Muddle Barn Farm  
Colony Road  
Sibford Gower  
Banbury  
OX15 5RY

**15/01693/F**

**Proposal:** Demolition of an existing dwelling and a range of large scale equestrian buildings and the erection of a replacement dwelling including associated works and landscaping (revised scheme of 14/02157/F)

**Recommendation:** Refuse

Ground Floor

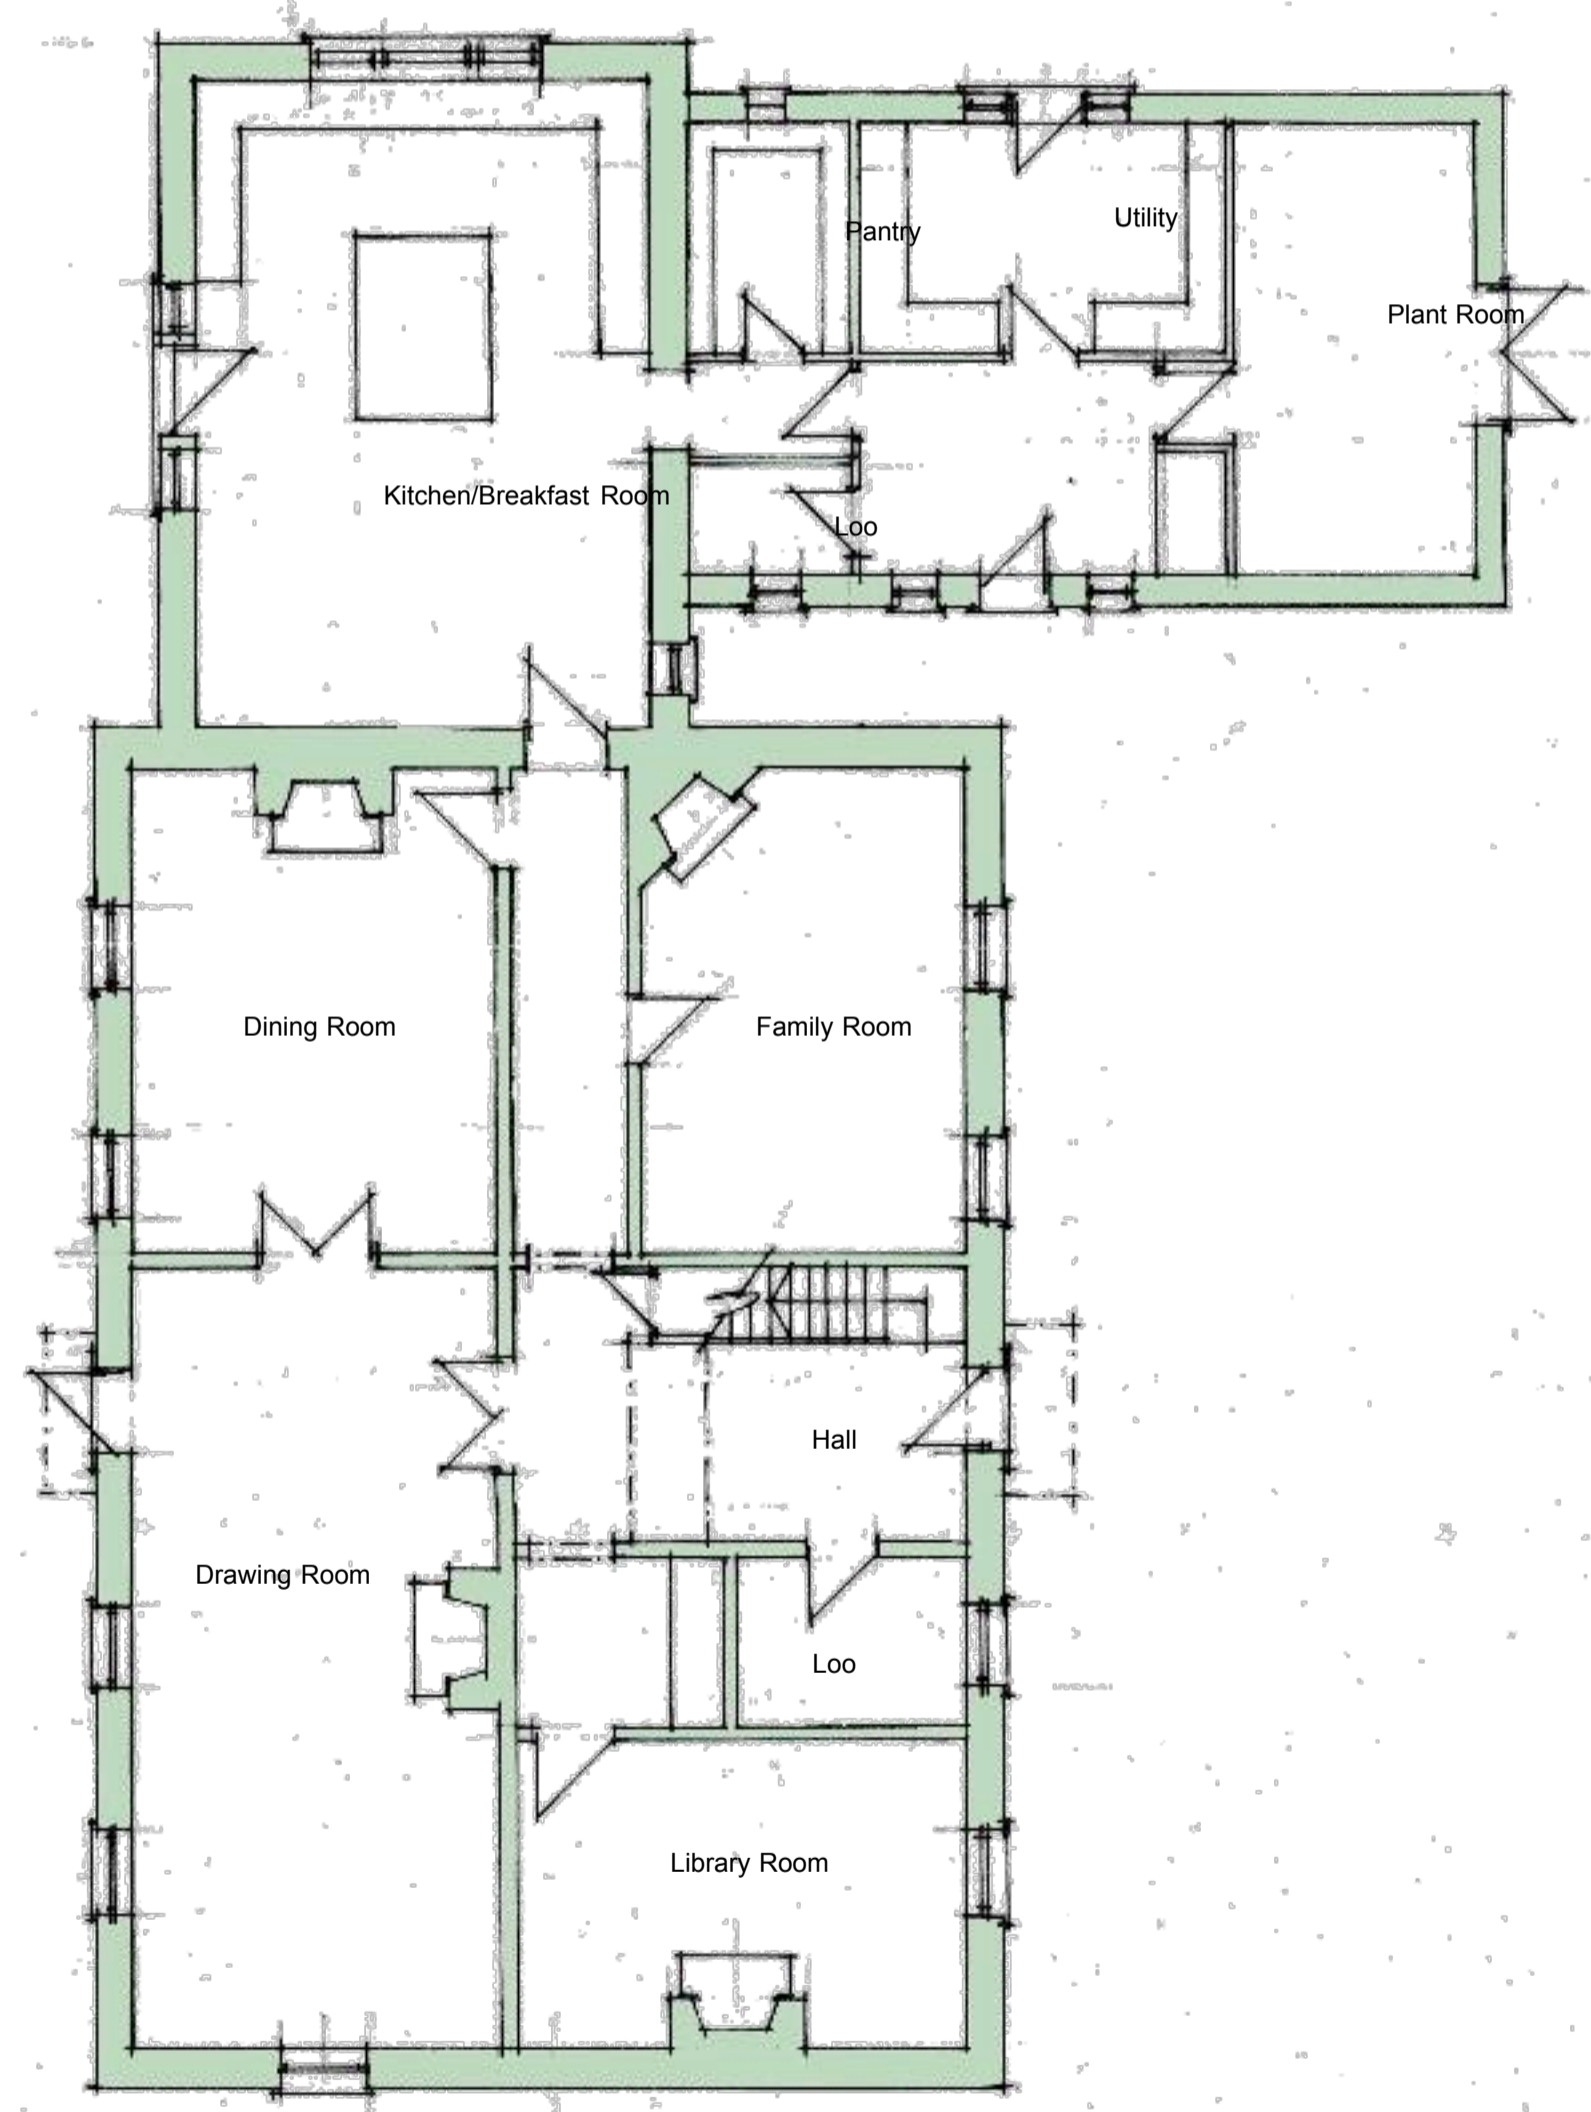
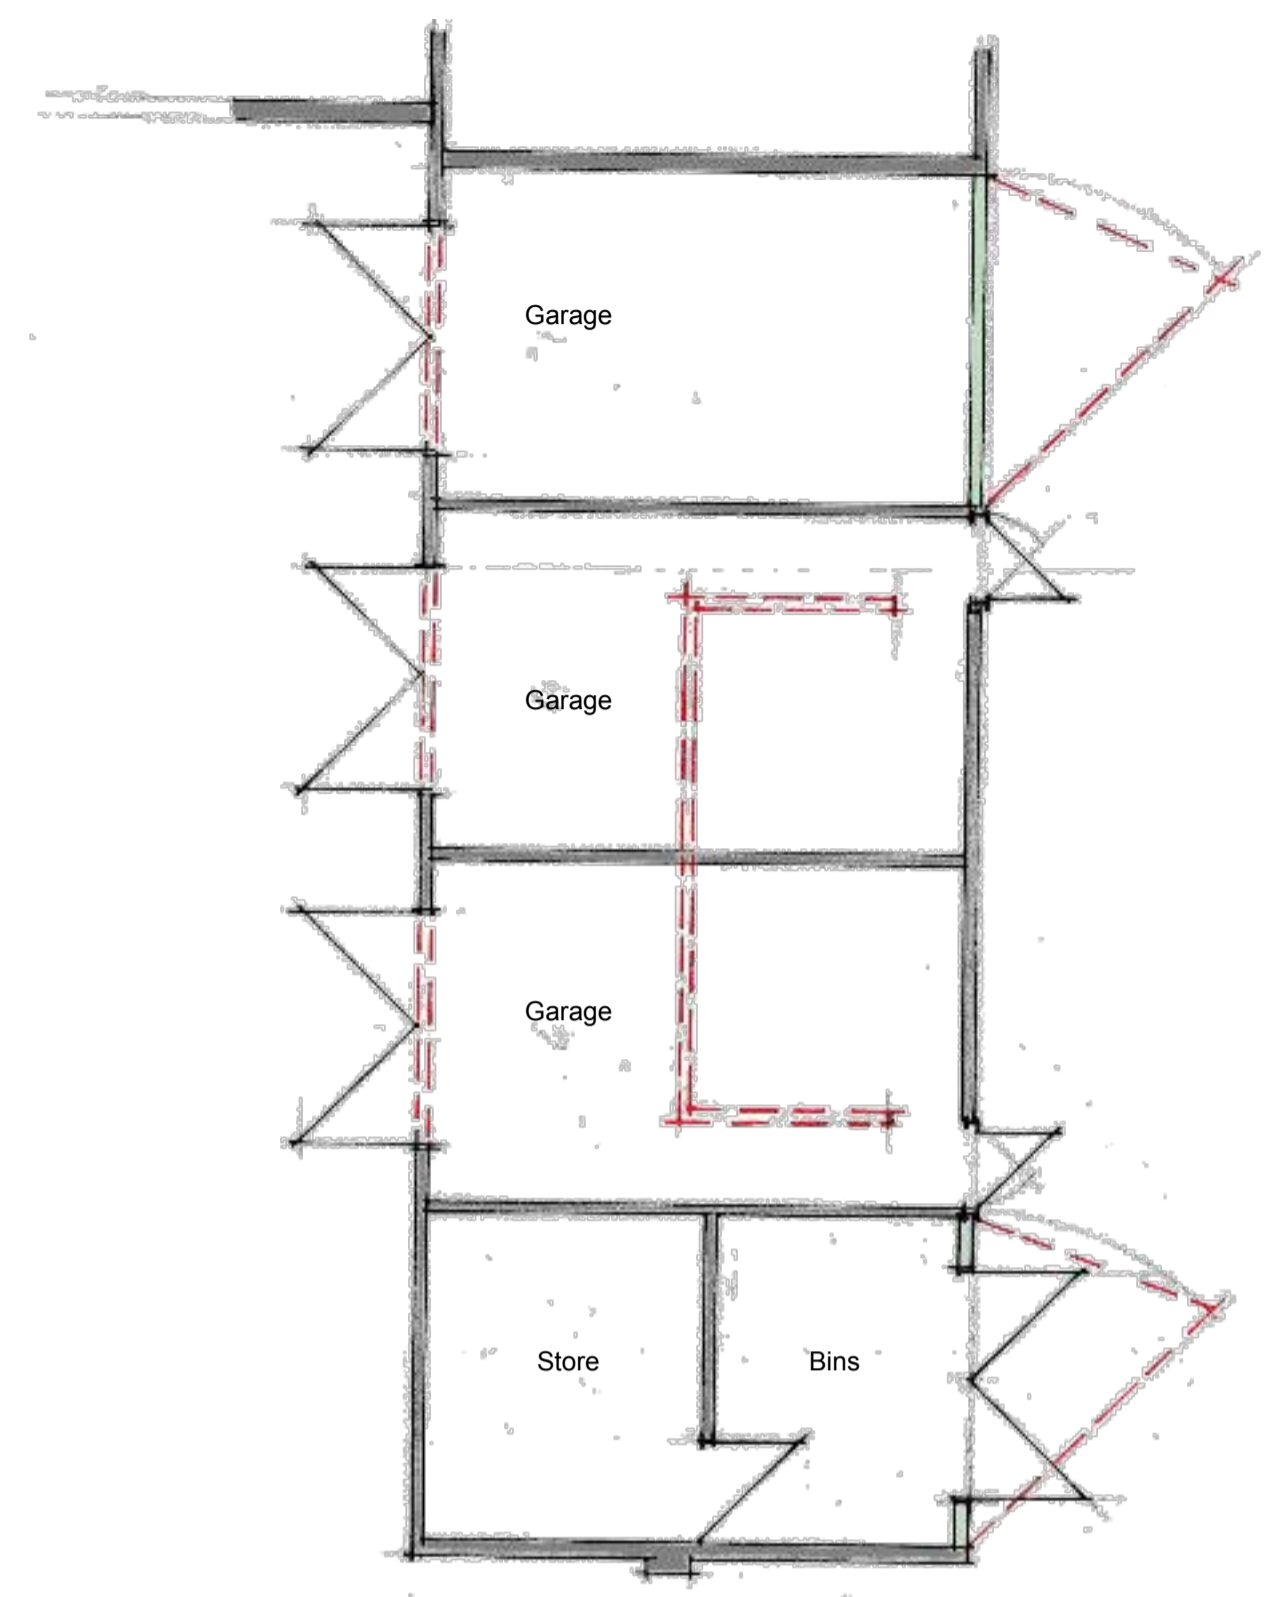
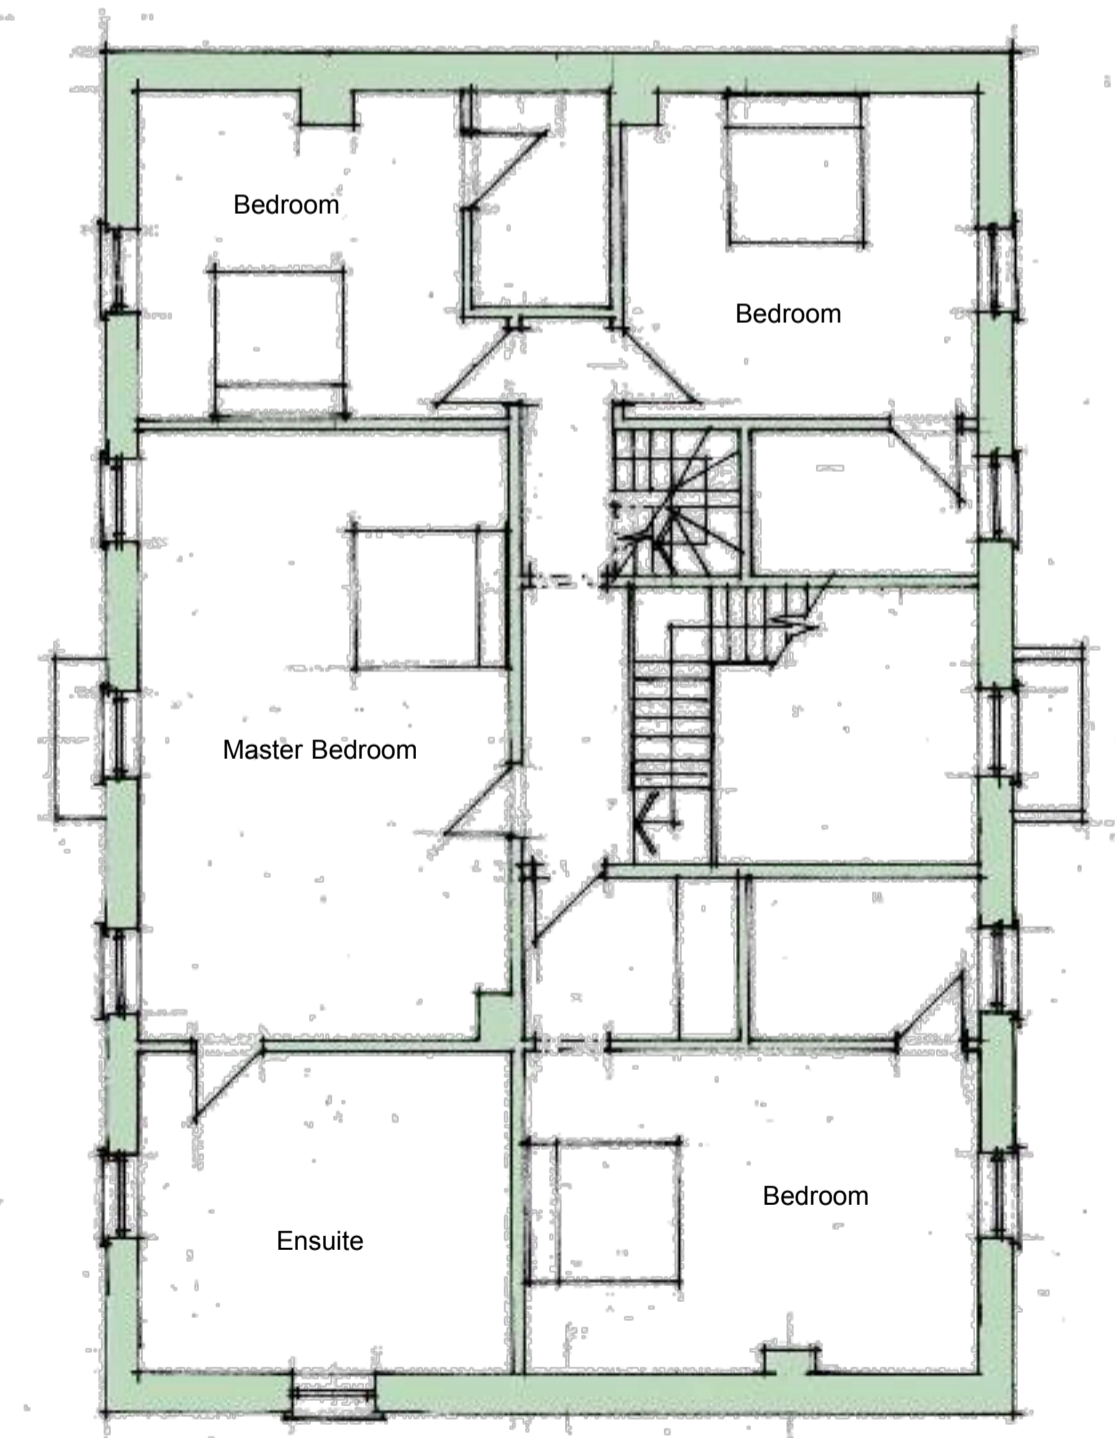
- The general form of the proposed kitchen extension and junction of the courtyard outbuildings needs further thought as the juxtaposition is cumbersome.

- There should be a stronger hierarchy between the main house and the courtyard. The proposal includes a very sizeable courtyard, the footprint of which is greater than the main house. Areas of this first floor are not yet allocated a use which suggests the plan area could be reined in.

- The orangery-style kitchen extension is very much an add-on and would look better centred on the north-west elevation of the main house. A subservient link to the single storey wing could make the junction between the kitchen and the northwest wing of the courtyard less awkward. The hipped roof beyond the conservatory

- The relationship of the eaves of the kitchen extension to the string course of the main house looks very similar and needs to be stronger. There is a drafting error: the south west elevation shows the lantern above the parapet but this is not shown on the north west elevation. The lantern light would be better hidden behind a parapet.
